Transport Infrastructure Planning Unit
Department for Transport
Great Minster House
33 Horseferry Road
London
SW1P 4DR

Date: 7th February 2025
My Ref: 20040633
Your ref: TR050007-002567
Contact: [REDACTED]
Phone: [REDACTED] [@leics.gov.uk](mailto:[REDACTED]@leics.gov.uk)

Planning Act 2008 - Application by Tritax Symmetry (Hinckley) Limited for the proposed Hinckley Rail Freight Interchange Development Consent Order

Further to your consultation letter dated 20 December 2024, please find attached our comments on the additional information submitted by Tritax Symmetry (Hinckley) Limited on 10 December 2024.

**SAPCOTE ENHANCED
SCHEME
VISIBILITY TO
PEDESTRIAN CROSSINGS**

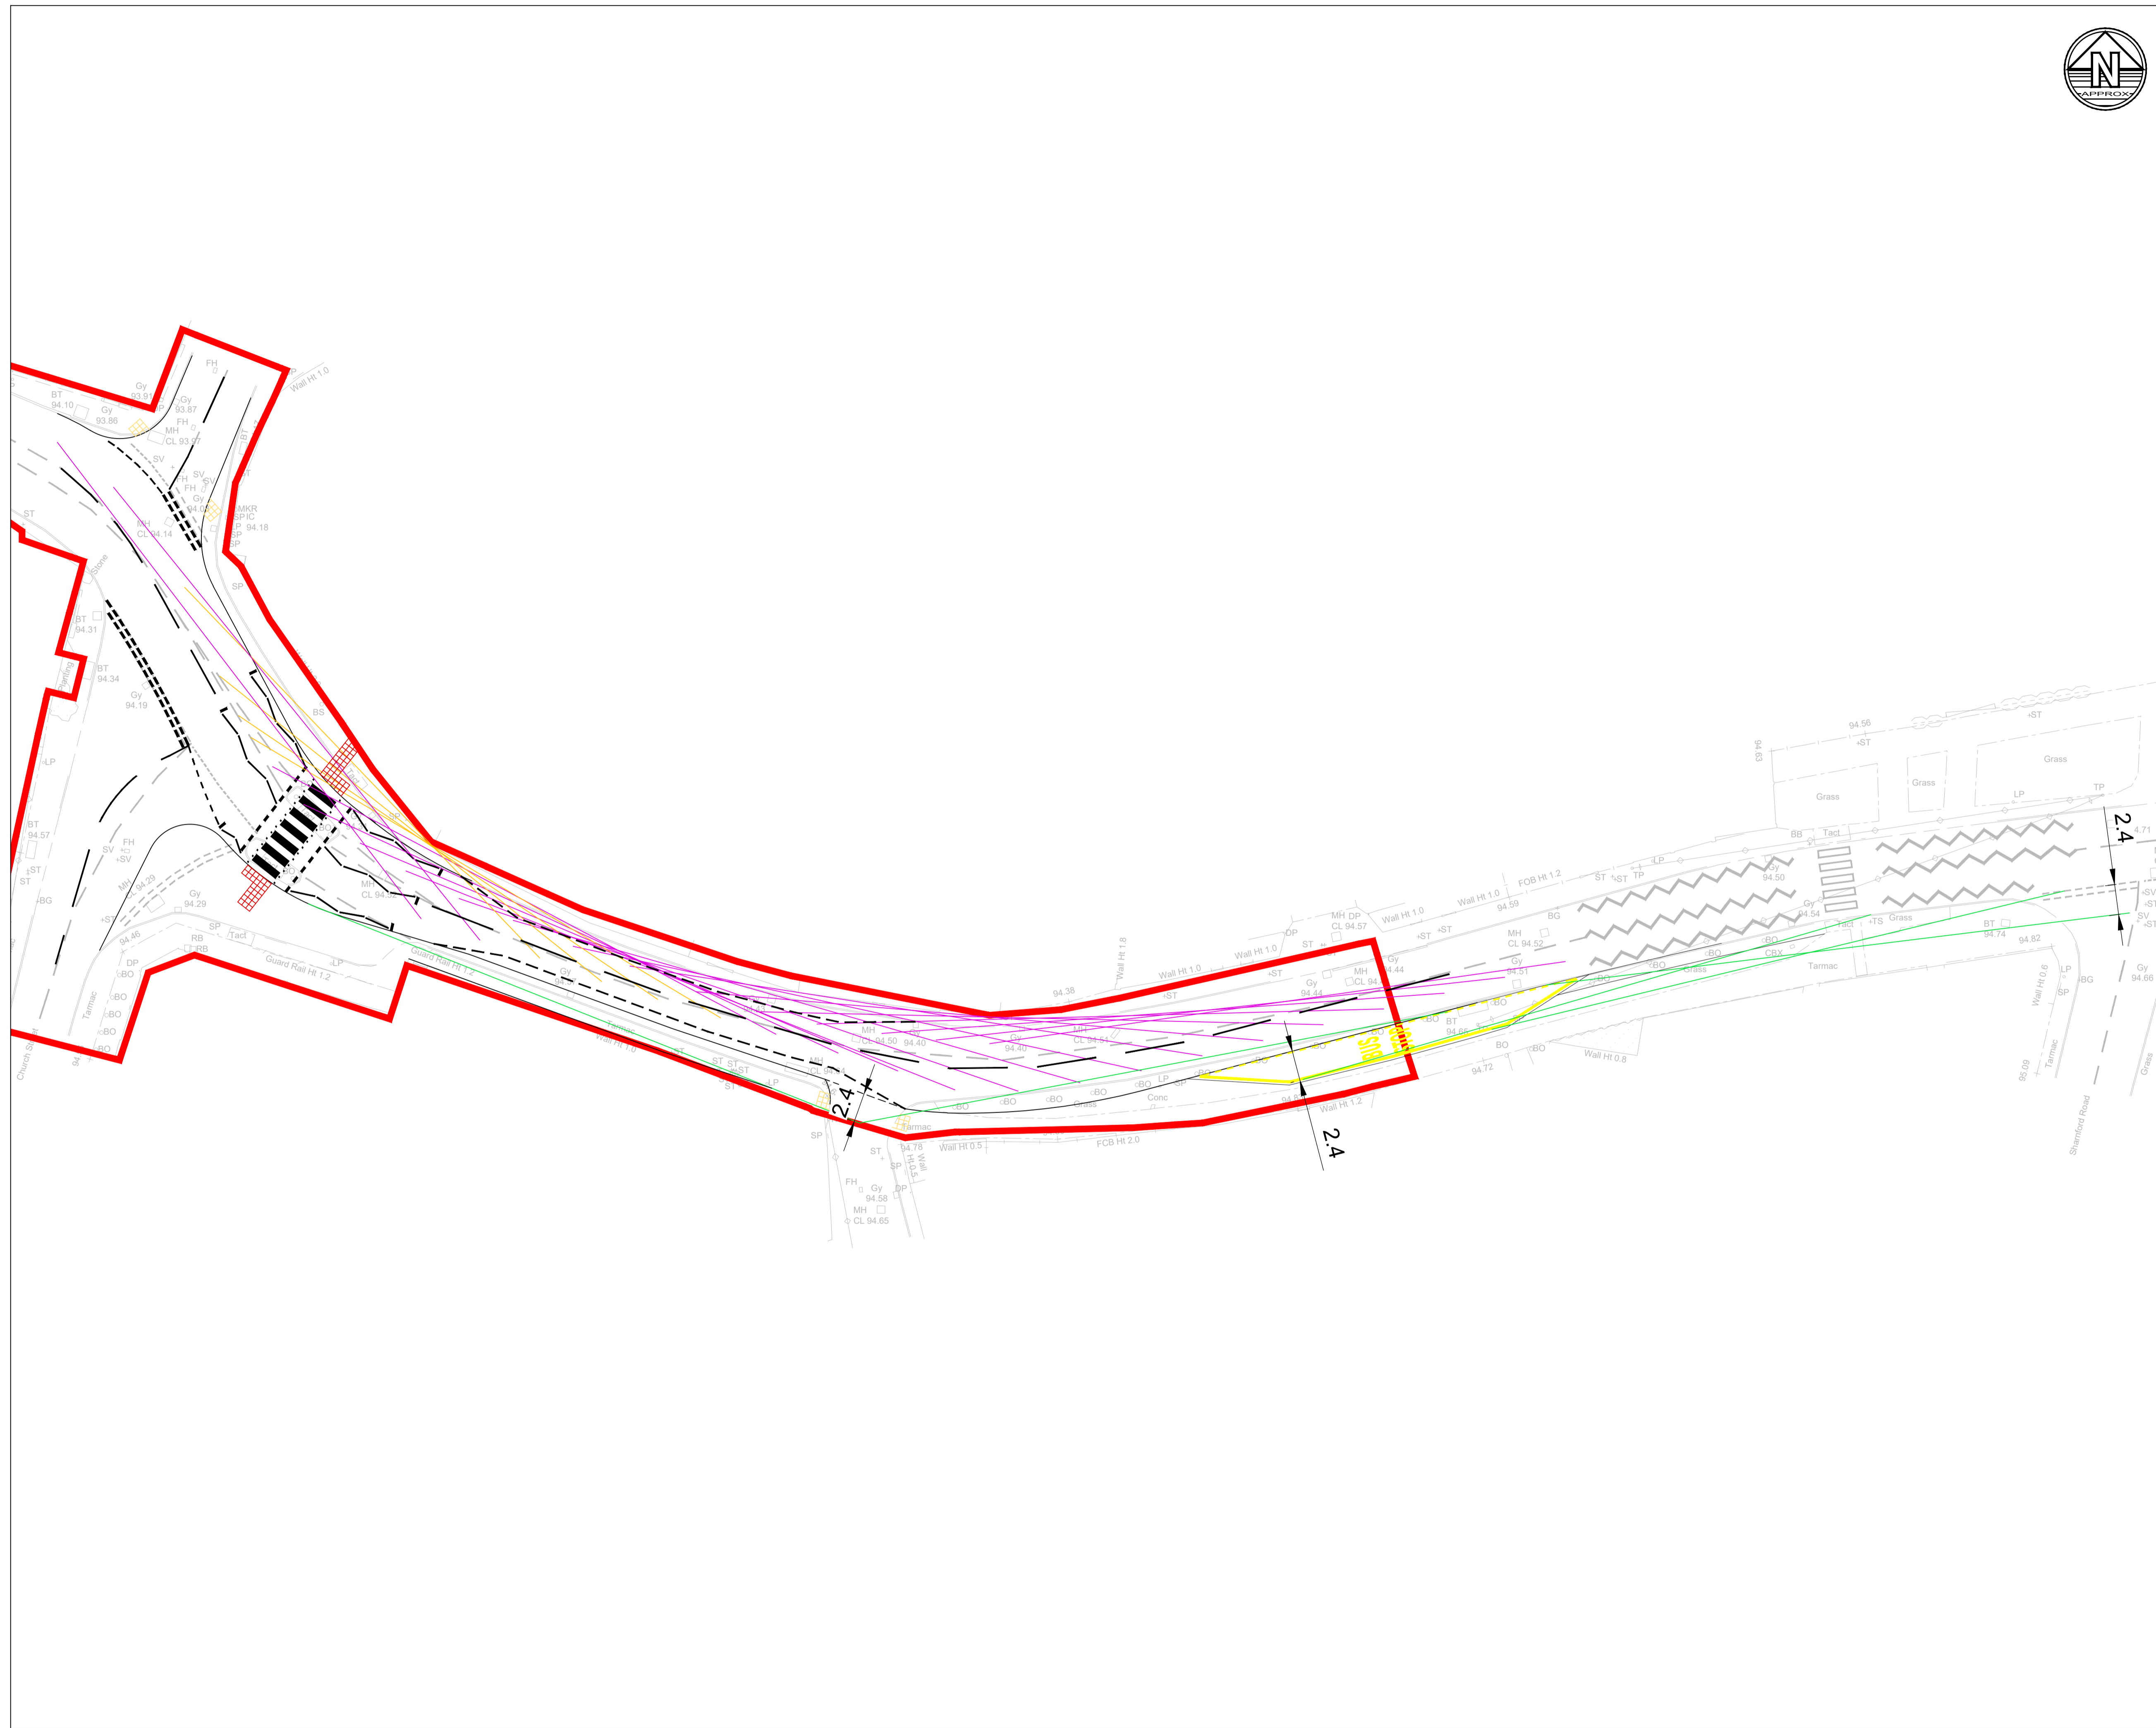
Highway safety concerns were also raised within the original RSA [REP8-025] in respect of forward visibility to the proposed zebra crossing. The Applicant has submitted a drawing [Sapcote enhanced scheme visibility to pedestrians] within Appendix C of the Technical Note attempting to show that vehicle to pedestrian visibility is not an issue. However, this is not the case.

In the extract below, the SoS will note that any pedestrian stood within the blue hatched area will not be visible to oncoming vehicles from the east or vice versa given the prevalence of an existing building line. There will realistically be pedestrians waiting in this area stepping back from the kerbline that will be over-ran by large vehicles, as a consequence of a number of pedestrians wishing to cross at any one time, or as a carer pushing a buggy or a wheelchair. Indeed, the Applicant has measured a setback of 1.2m contrary to the DfT guidance on Inclusive Mobility³ that identifies dimension requirements for vulnerable users in excess of this.
